Subject: FW: EA and LLFA comments

Subject: RE: EA and LLFA comments

drg.no. 14/59 PL01 rev. H

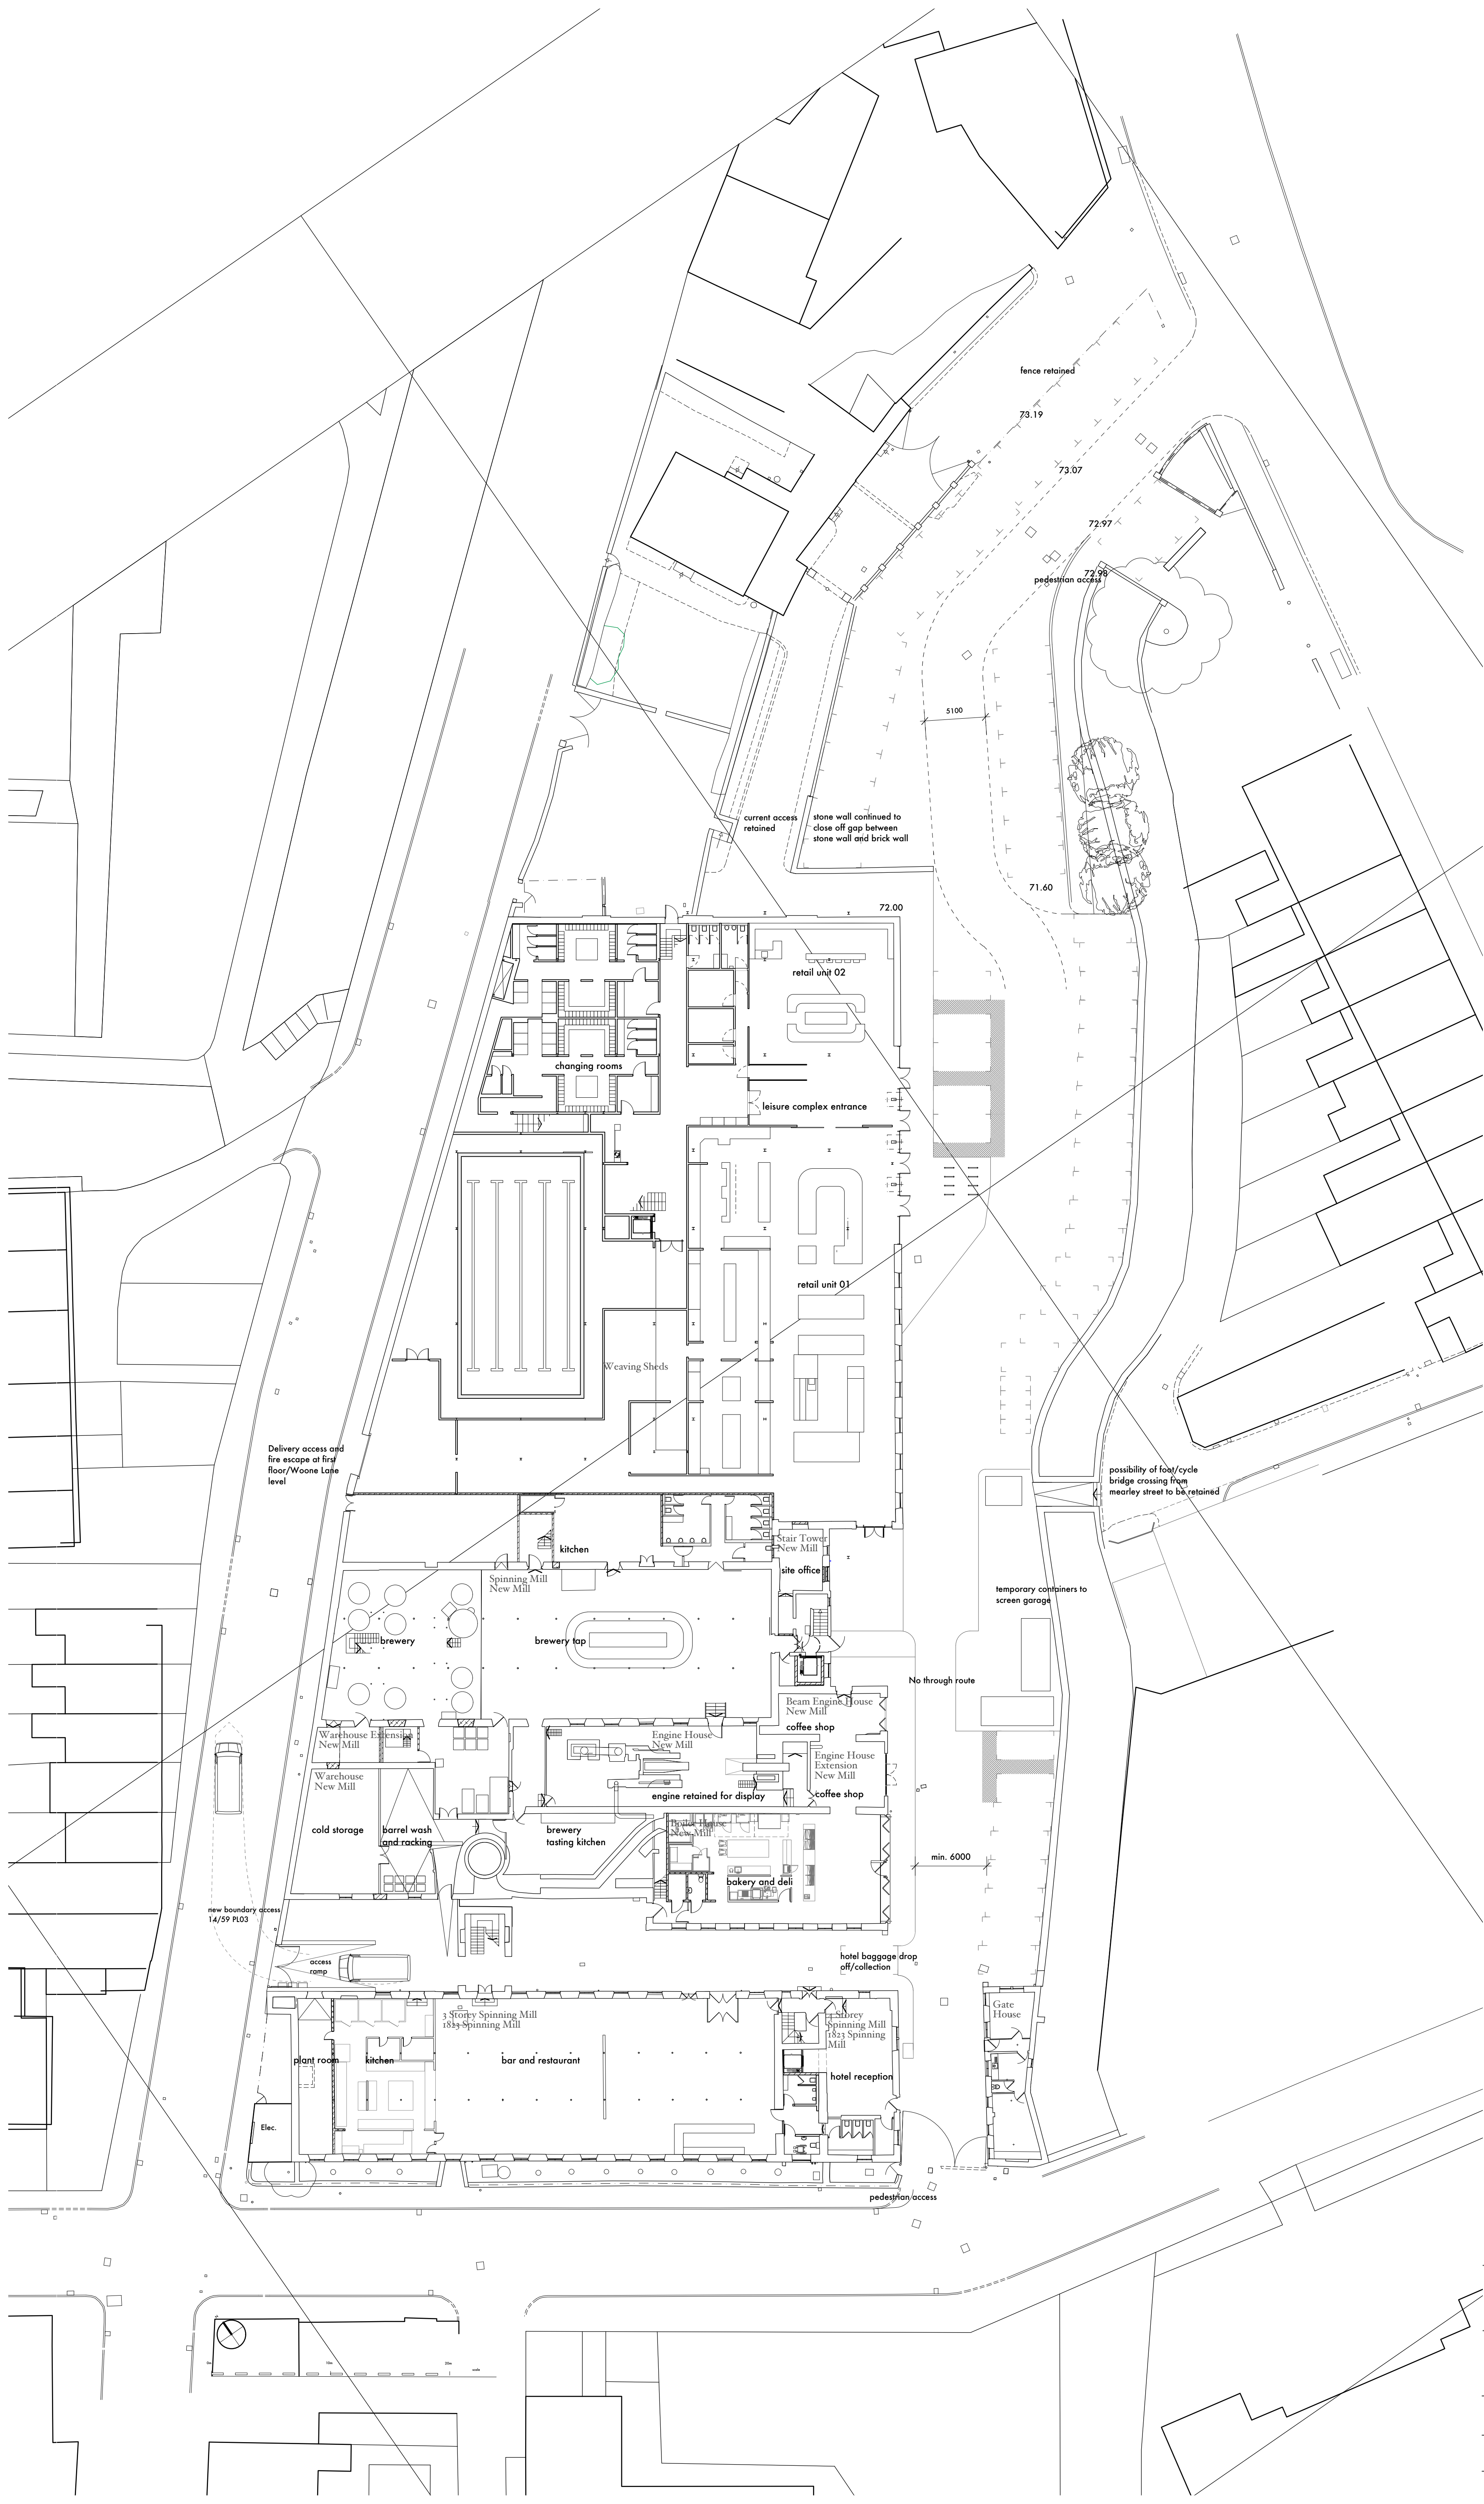
In terms of the EA's response I can confirm that the existing wall which runs along the site's eastern boundary next to Mearley Brook is to be retained in its entirety, which should address their concerns (please relay to the EA).

drg.no. **14/59 SKPL3** rev. **B**

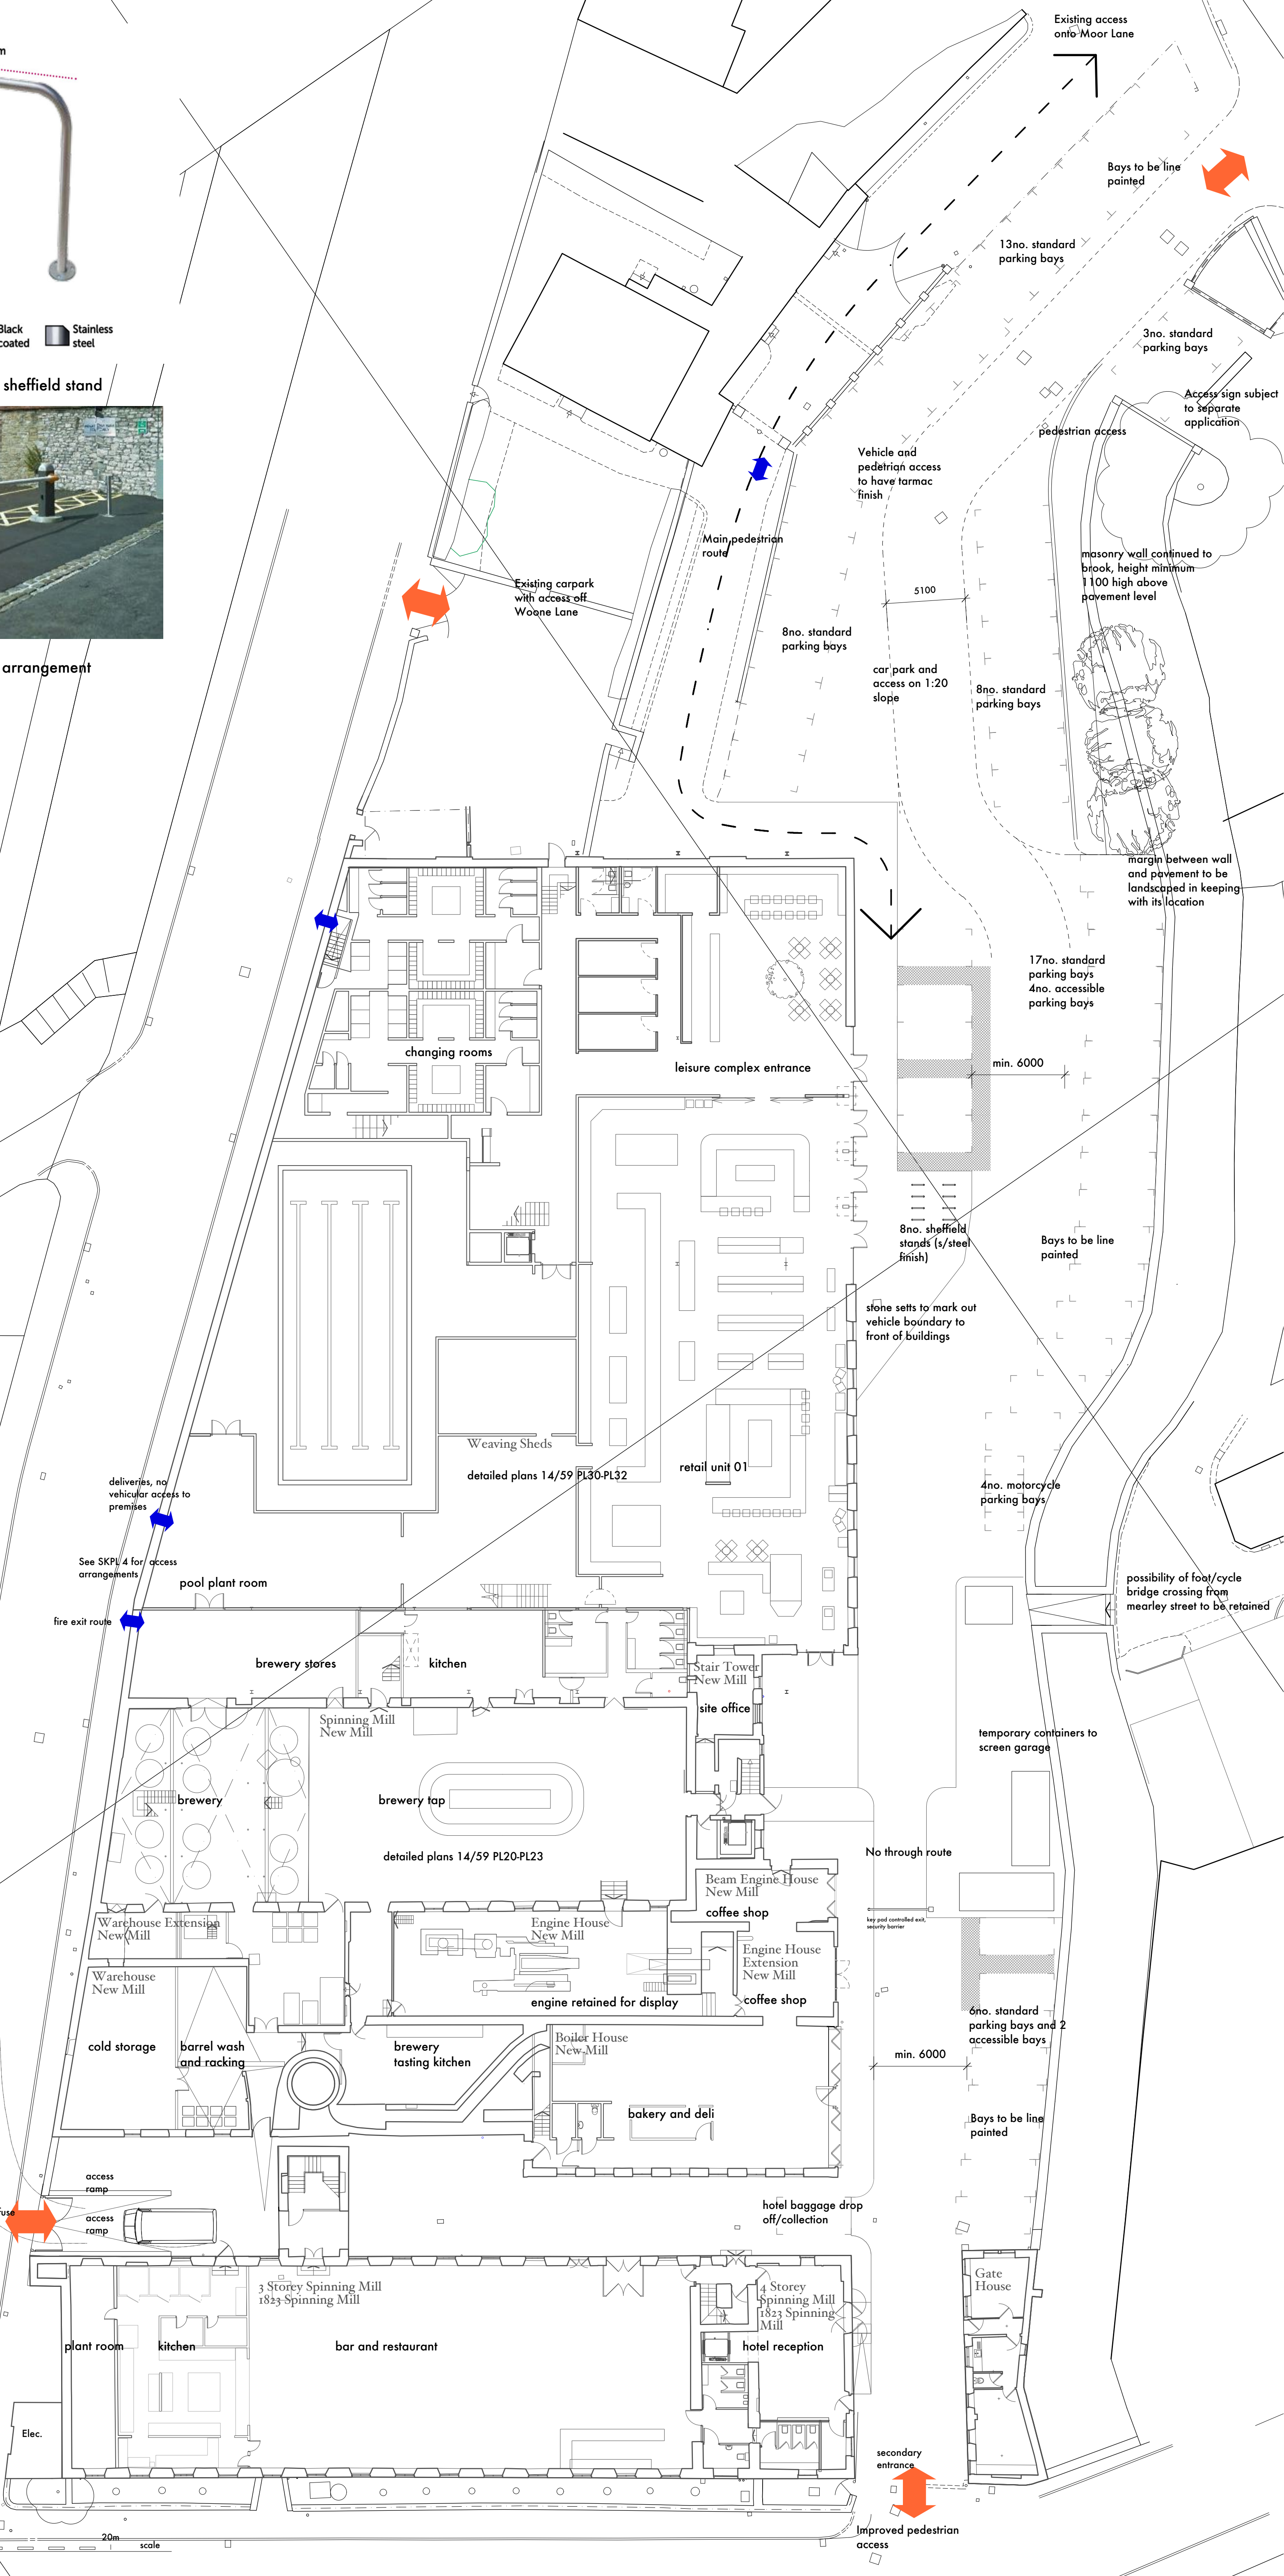
With this set of updated drawings, at the request of LCC Highways we will include additional detail to drawing 14/59 SKPL13 Rev A re: the pedestrian access from the north through the inclusion of an additional annotation / dashed line which clearly marks out the route for pedestrians through the site from this access point. In terms of LCC Highway's other comments / requests, Croft Transport Solutions are to provide details for the barrier control system within the centre of the site which should in turn avoid a condition to 3/2017/0270 requiring approval of such details. Croft are also picking up the issue of the pedestrian refuge area on Moor Lane (Option 2).
